**STORMWATER MANAGEMENT REPORT
FOR
URBAN COLLECTION AT PALMER VILLAGE**

October 28, 2020
Project No. 25149.01

PCD Filing No.:
SF-20-028

URBAN COLLECTION AT  
PALMER VILLAGE  
SWALE CROSS SECTIONS  
GEC PLANS

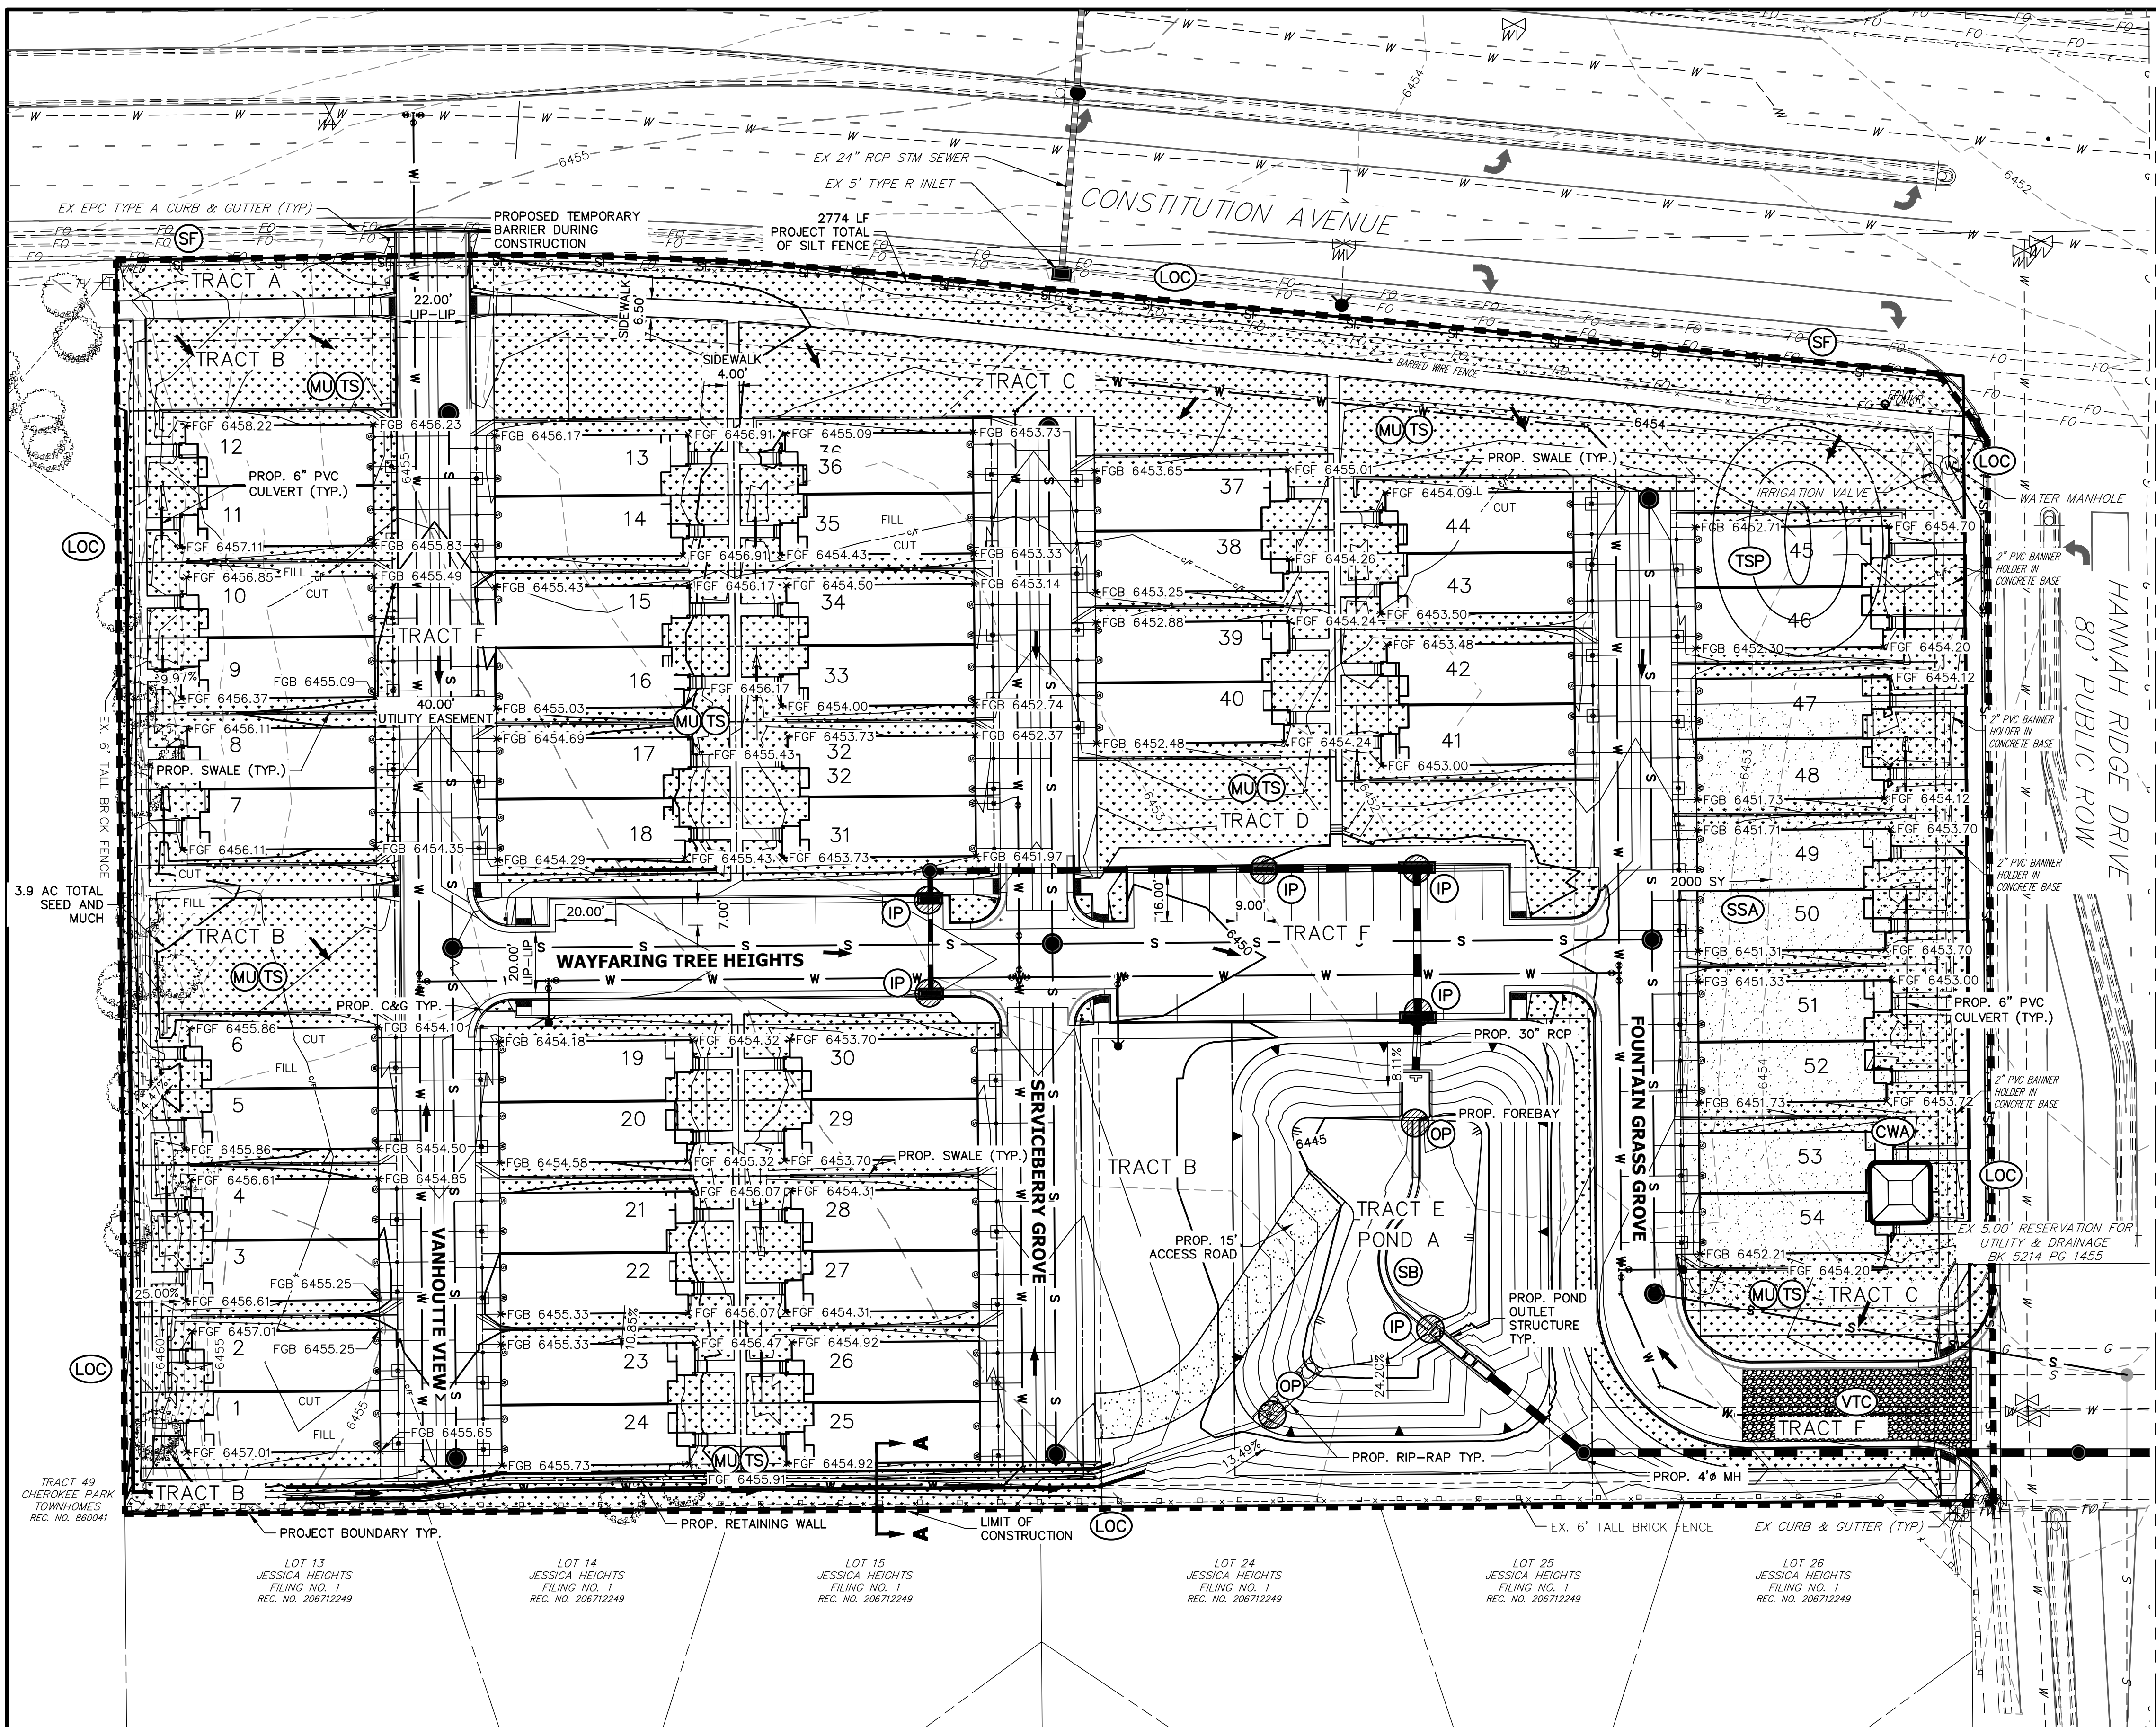
also discuss the use of swales, sediment basins, and outlet protection which are all shown on the GEC Plans.

GEC Plan shows rock check dams on Sht 8 and on plans in swale. Discuss rock check dams in SWMP.
